CITY OF ALBUQUERQUE

February 12, 2018

RE: **Jackson Middle School Cafeteria**
10600 Indian School NE
Request for Certificate of Occupancy – 30 Temporary
Hydrology Final Inspection - Approved
Engineer's Stamp Date 5/23/17 (J21D029)
Certification Dated: 1/27/18

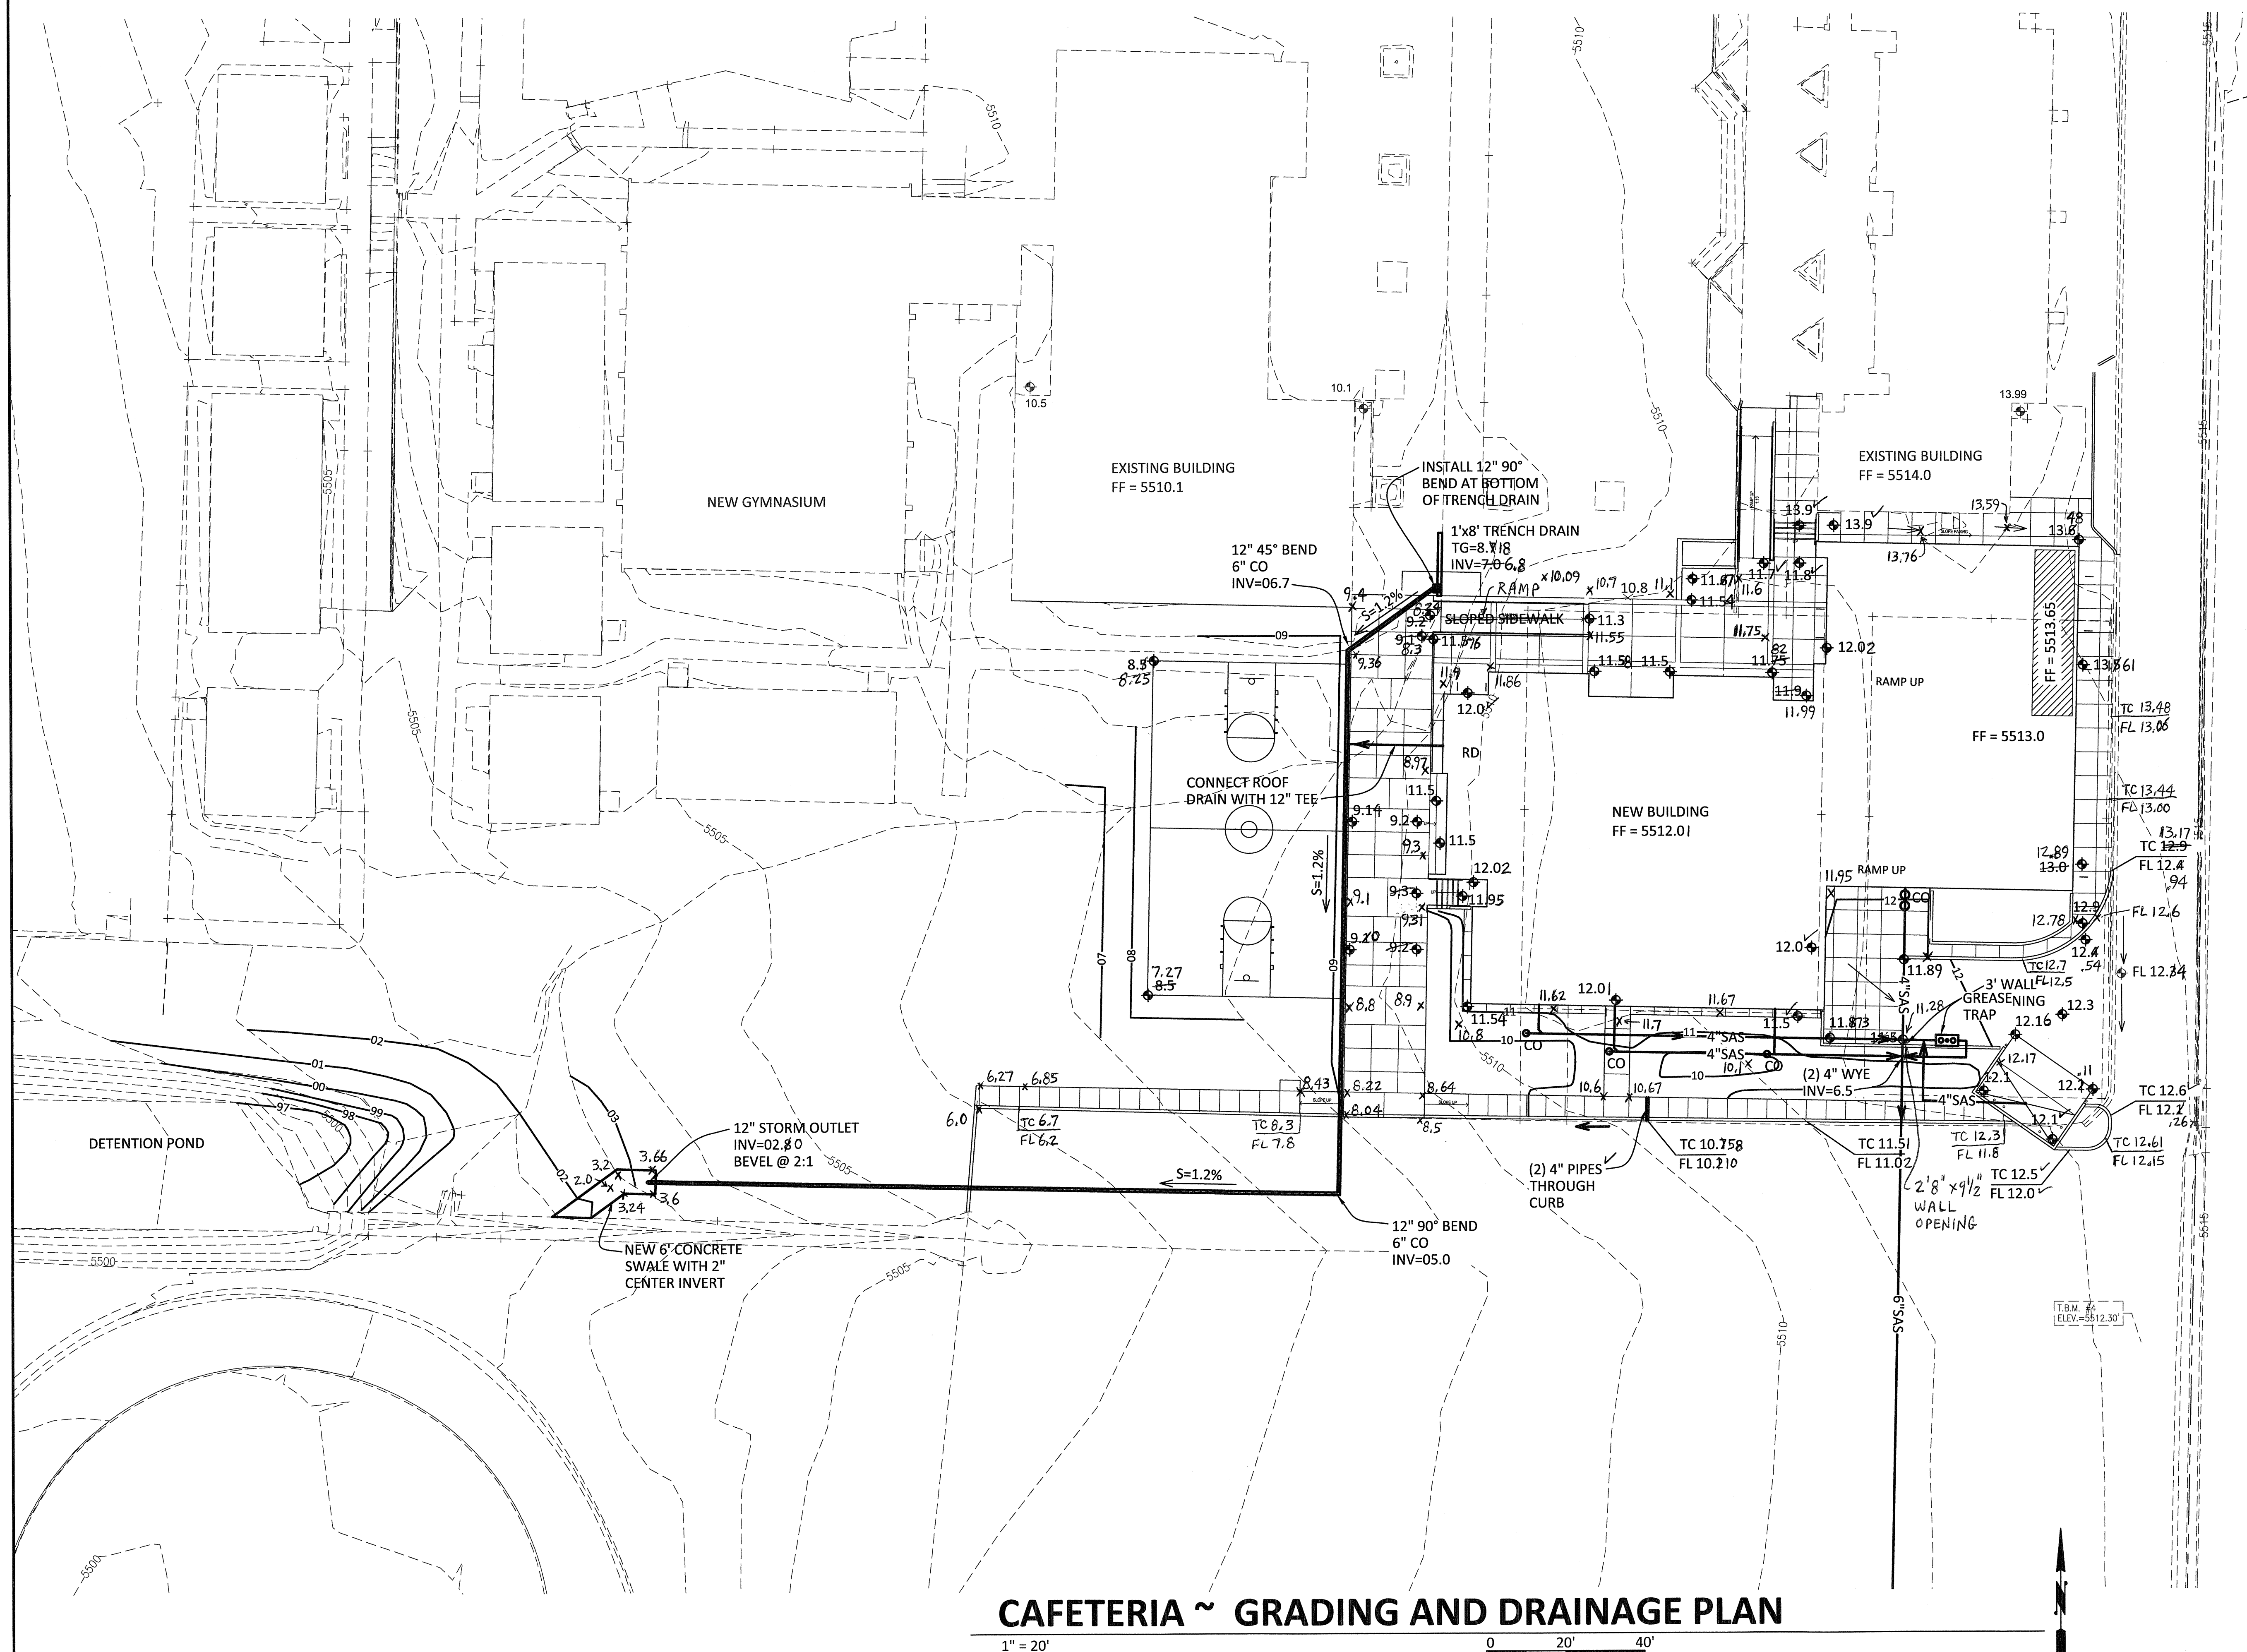
1. The detention pond needs to be excavated and enlarged as shown in the approved Grading and Drainage Plan. Once complete, the enlarged area will need to be surveyed, re-certified, and a new Engineer's Certification submitted to Hydrology.
